Application No: Y/42/20/PL  
Site Address: The Crickets Hoe Lane Flansham Yapton PO22 8NT  
Description of works: Extension & alterations to main dwelling & conversion & extension of existing annexe to 2 No. holiday letting units (resubmission following Y/117/19/PL).

Thank you for your internet representation made on 5th June 2020 which has been recorded as an objection with the comments as follows:

Drawing P103 April 2020 Scale 1:100 @ A3
Planning Drawing - SW & NE Elevation

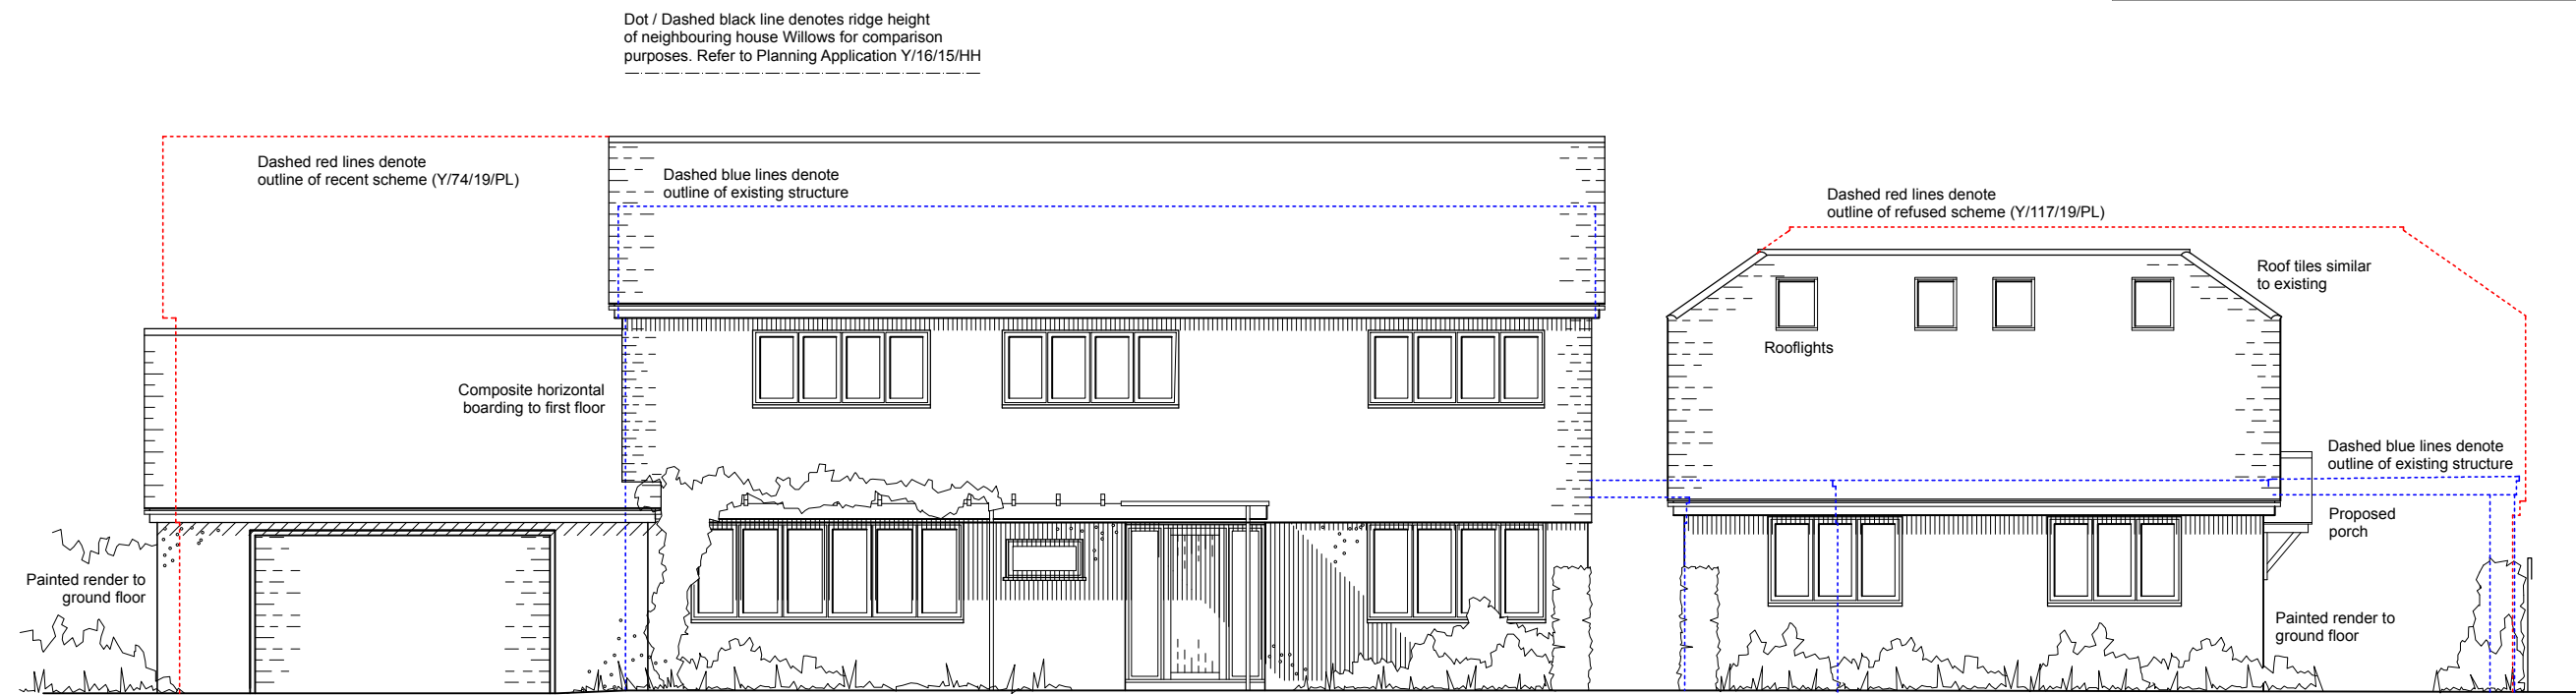
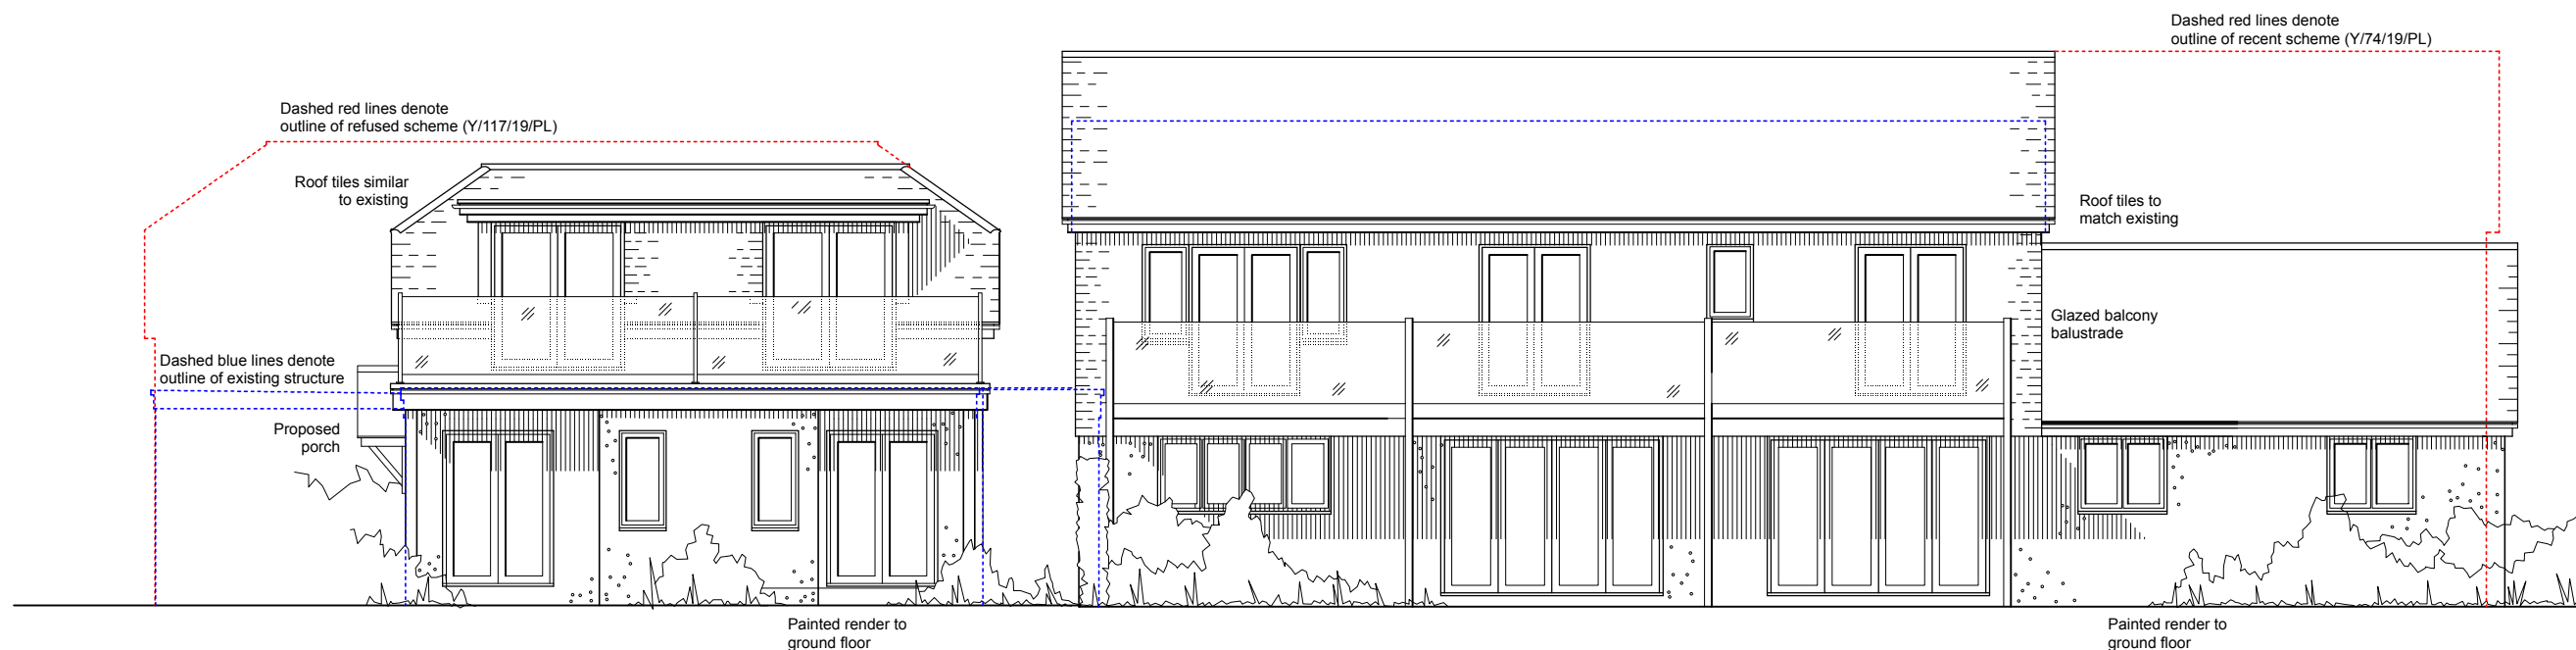
2. The proposed extension of the residential dwelling whilst large is in keeping with the current two storey structure. However, the proposed holiday lets building is a substantial departure from the existing structure's size and proportions. YPC believe that the proposed holiday lets are a significant overdevelopment of a small
